23 February 2021

SF2011/002339; WST11/00046/18

**MP10_0191_MOD-6: Lot 664 DP 761702 & others; 353 Burthong Road, Nymagee
Hera Mine Mod 6: 100ktpa ore, rock and 60ktpa mineral concentrate transport**

Figure 3. Main route for the transport of concentrate from the Site to the Hermidale rail siding.

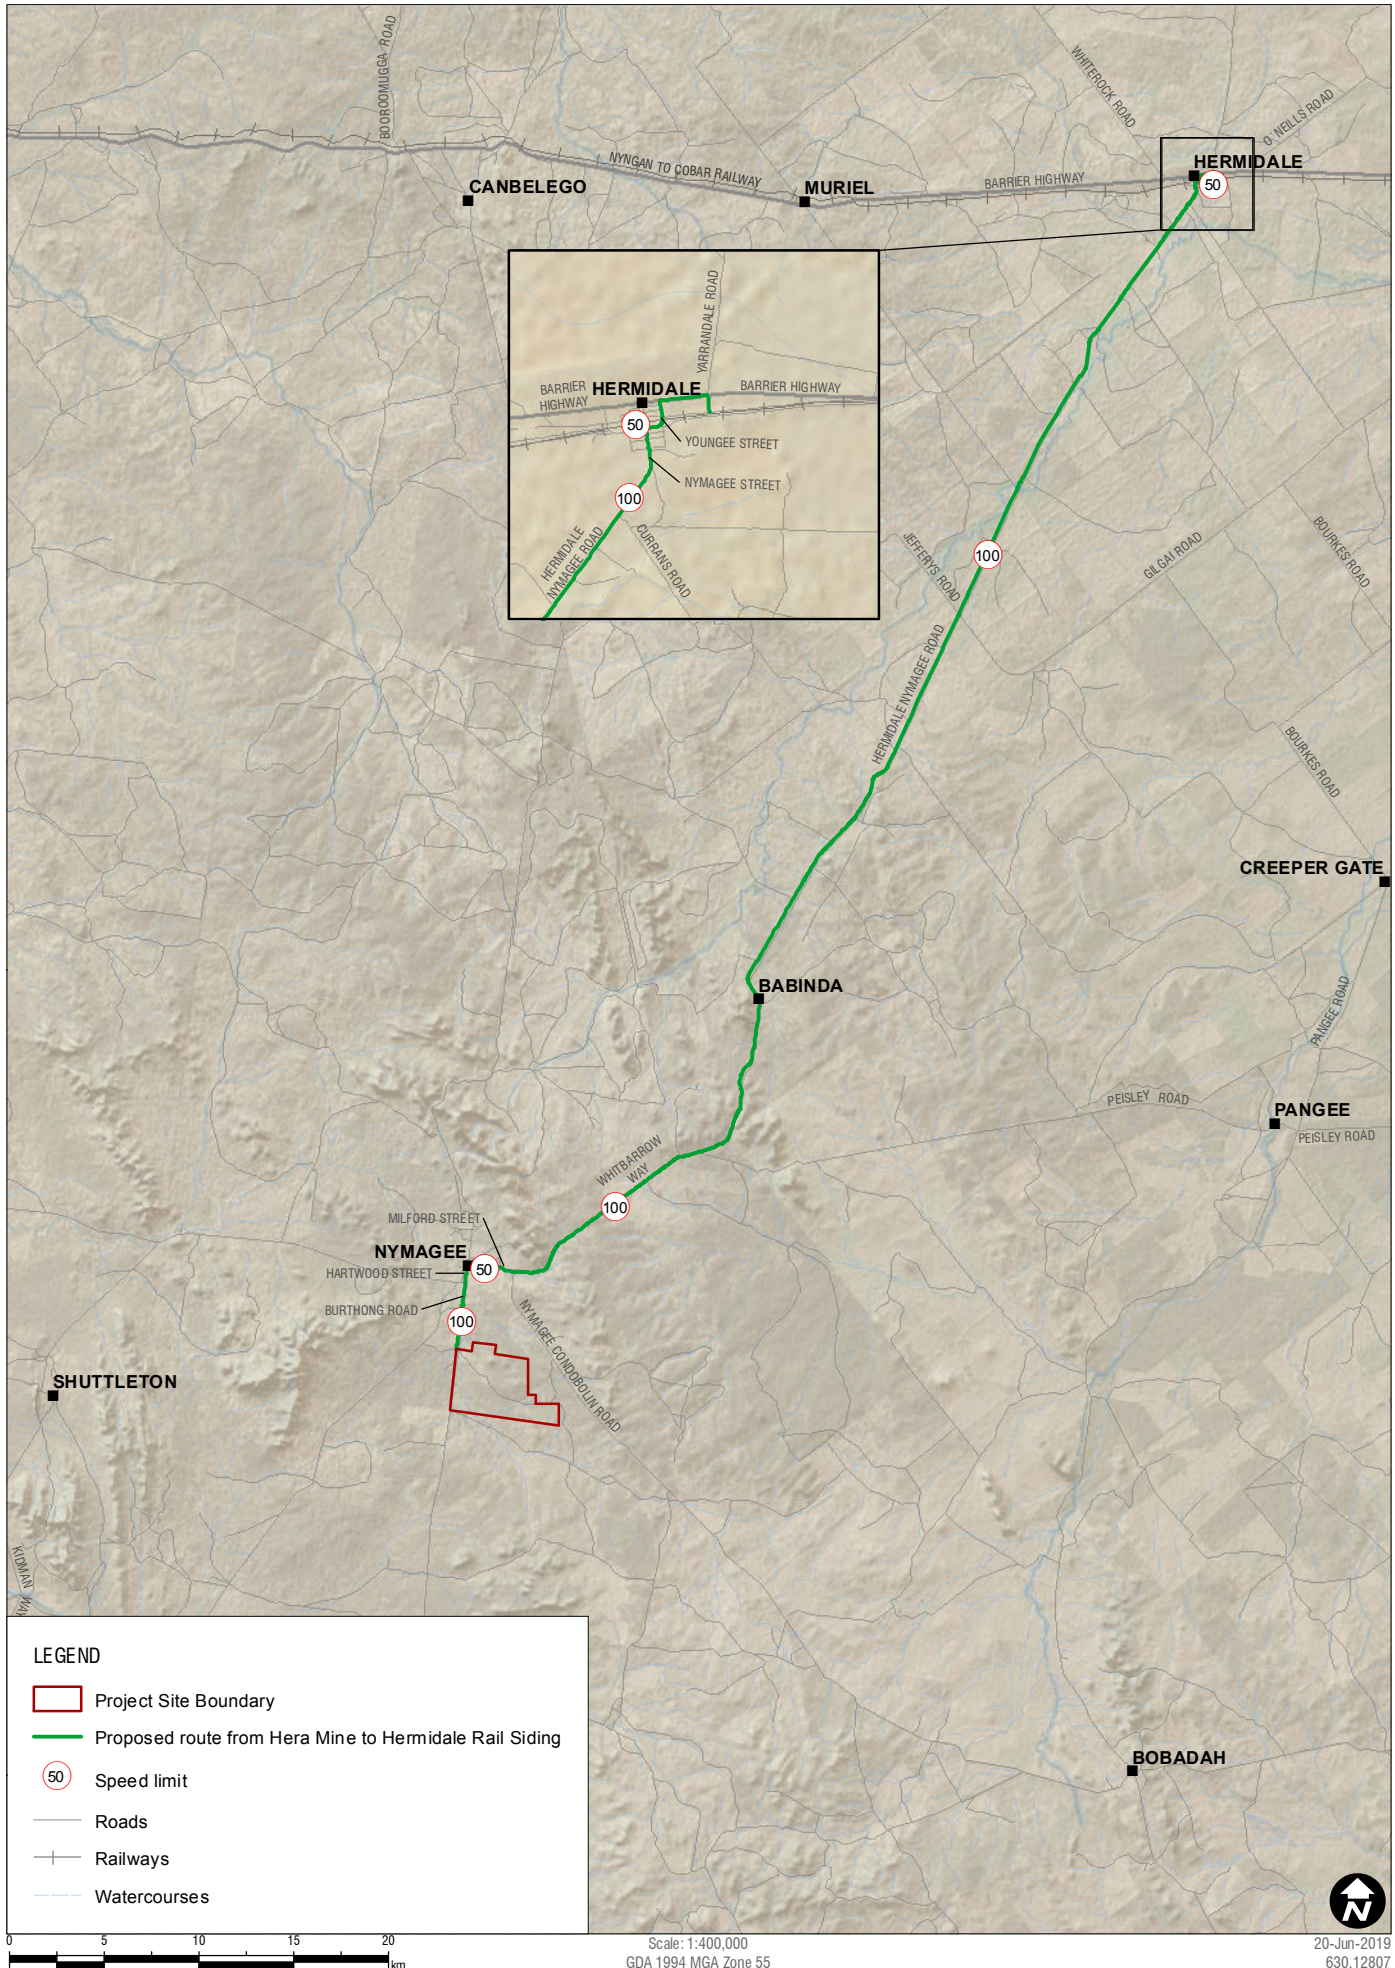
- A public complaint resolution and disciplinary procedure.
- Condition 38 shall be amended to require the existing Traffic Management Plan be reviewed and modified to align with the proposed modification, in consultation with Cobar Shire Council and TfNSW.

- To continue to limit mineral concentrate movements to eight (8) per day averaged over a calendar month, condition 37A of MP10_0191 consent is to remain in force following determination of MOD-6.
